**SSD 6010 - One Residential Building (Student Accommodation) within Darling Drive Plot**

**Submission by:**

**30 July 2013**

## Summary

# Peak Apartments

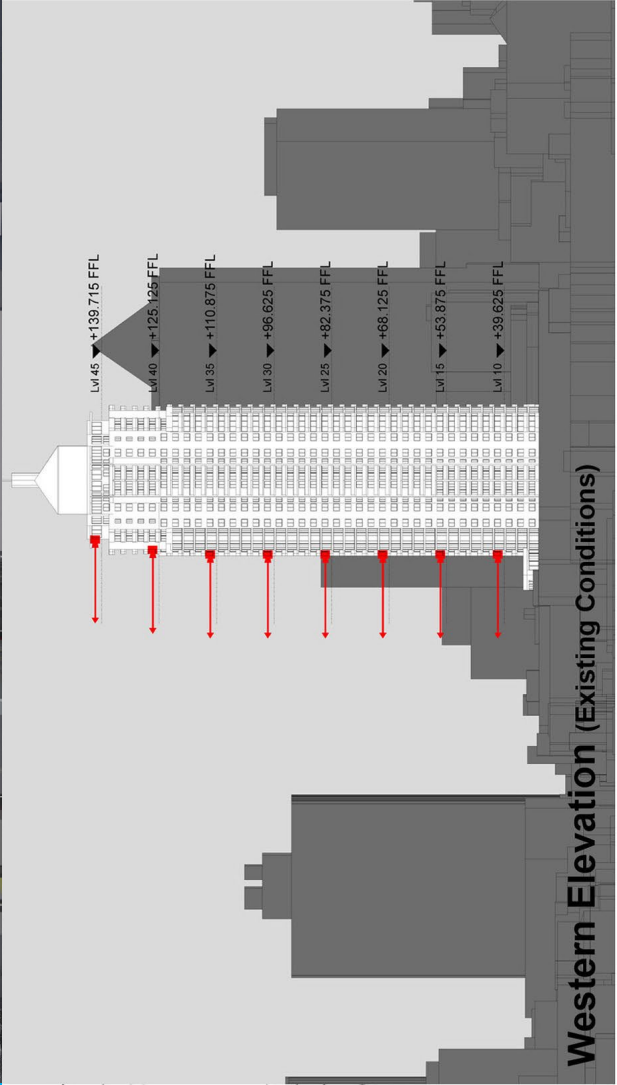
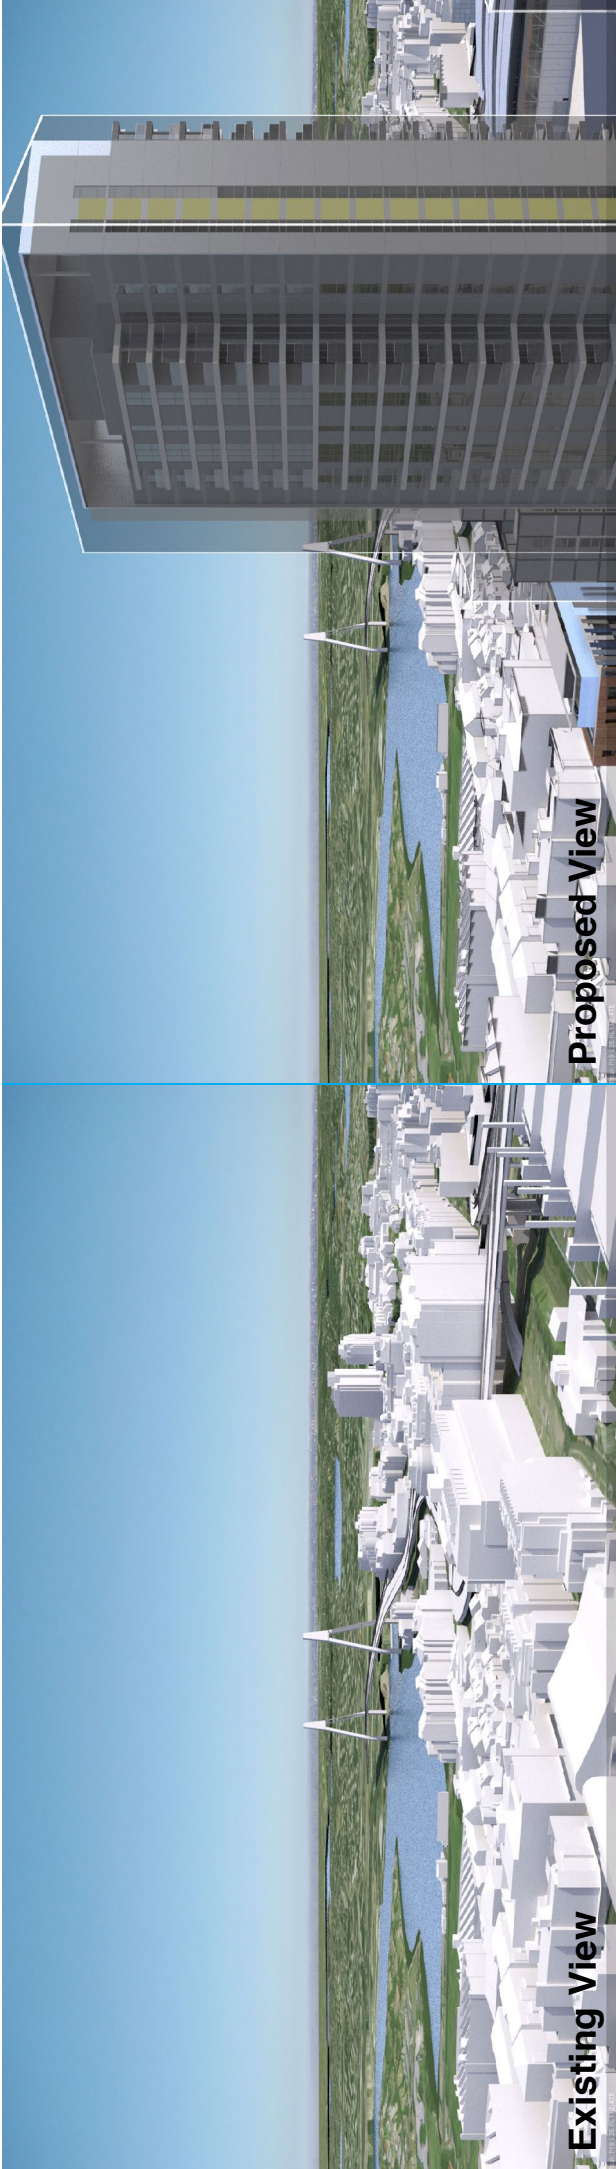
The proponent provides diagrams but fails to discuss the existing shadowing of the west façade of The Peak.

At 9am, 10am and 11am the west façade is totally in shadow due to other parts of The Peak building itself.

At 12pm there is still substantial existing shadowing on the west façade caused by the irregular shape of the west facade.

At 1pm the existing shadowing has been substantially removed, but not totally removed.

It can be concluded that some single aspect apartments on the west façade and some south-west dual aspect corner apartments currently receive less than 2 hours direct sunlight to habitable rooms and 50% of the private open space between 9am and 3pm on 21 June.

At 1pm the existing shadowing has been substantially, although not entirely, removed. However, overshadowing of lower levels of the west façade by the concept proposal parameter plan shadows for the N,NE and SE plots has already started.

By 2pm the existing shadowing has been totally removed. However, overshadowing of the west façade by the SSDA4 and SSDA5 buildings has appeared and risen further up the west façade than the concept proposal parameter plan shadows for the N,NE and SE plots, which is still present.

At 3pm, the proponent states correctly that 45-45% of the western façade is overshadowed by the SSDA4 and SSDA5 buildings.

It can be concluded that, as a result of combination of the proposed development with existing shadowing of the west façade, some single aspect apartments on the west façade and the south-west dual aspect corner apartments which currently receive less than 2 hours direct sunlight to habitable rooms and 50% of the private open space between 9am and 3pm on 21 June will suffer additional overshadowing. It is beyond our skills to count the number of such apartments. We note that the proponent has made no attempt to do so.
